Old	New
n/a	2020.04.16-RSA-Response – put in “Statements”
Dwg B 102 in “Additional Docs”	B190031 - The Ship Inn Aldwick Street Bognor Regis PO21 3AP - Planning-ReSized A1-202 - A1 Layout dwg B 202 Rev A
Dwg B 103 in “Additional Docs”	B190031 - The Ship Inn Aldwick Street Bognor Regis PO21 3AP - Planning-ReSized A1-203 - A1 Layout dwg B 203 Rev A
Dwg B 103 in “Additional Docs”	B190031 - The Ship Inn Aldwick Street Bognor Regis PO21 3AP - Planning-ReSized A1-204 - A1 Layout dwg B 204 Rev A
Site location plan with vehicle tracking refuse tracks passing delivery vehicles B 205 in “Plans”	B190031 - The Ship Inn Aldwick Street Bognor Regis PO21 3AP - Planning-ReSized A1-205 - A1 Layout dwg B 205 Rev A

I have had comments back from Highways on the RSA and tracking diagrams to say that:

“I would say that nothing at this point in time changes my view. I have read the audit again but without any designer or applicant comments its difficult to respond. I would ask that as designers of the scheme this is required so I can

comment on both as some of the comments/recommendations are beyond my remit. I would also like to highlight that the tracking plans will need to be re-done to be as realis

Drawing No:
B 102

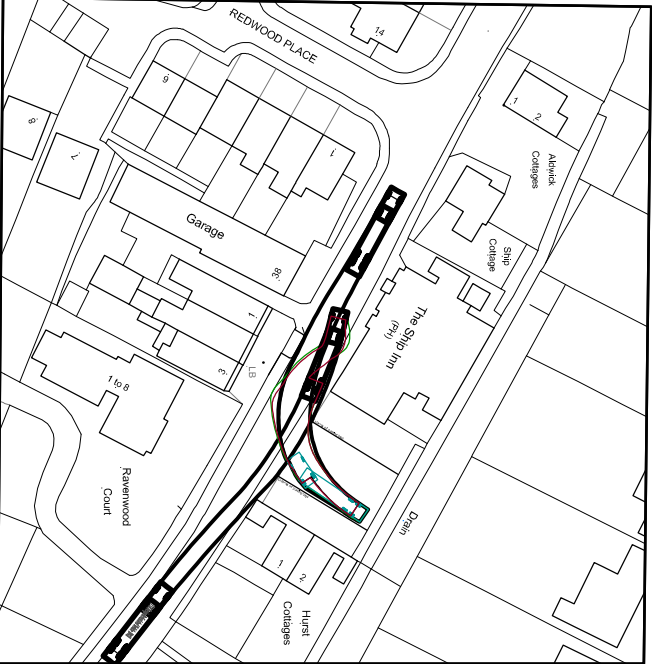
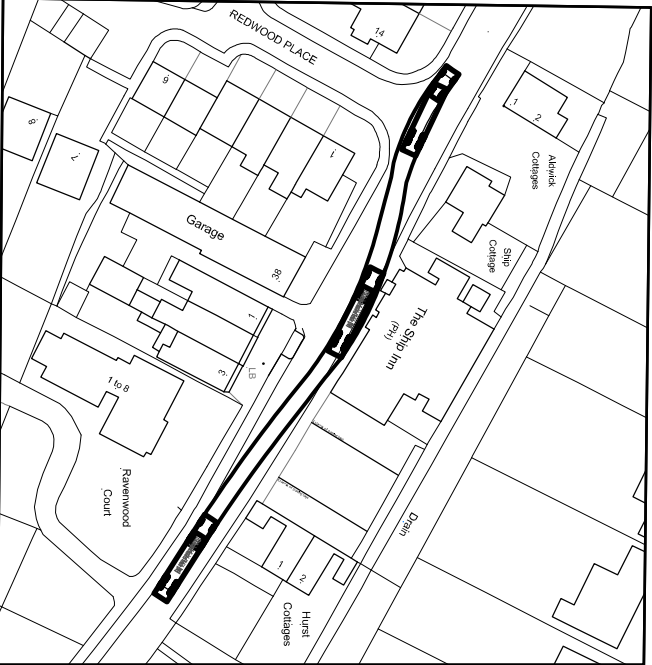
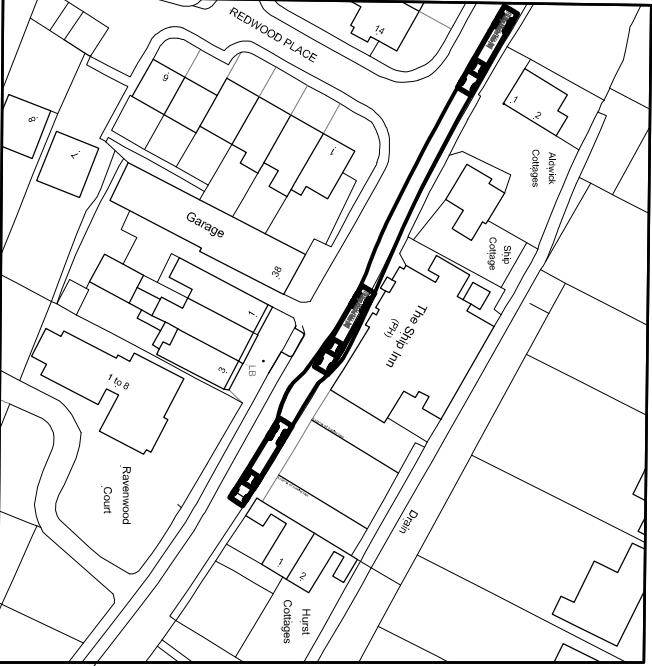
Can you provide us with a Designer/Applicant Response on the points in the RSA and also amend the tracking diagrams? Otherwise we would be going back to the Ctte with the points made by Highways unanswered.

I have also amended each of the tracking plans with the parking areas discussed in the below, and have also added a layout to drawing 202 with some dimensions relating to carriageway widths, all as per the comments.
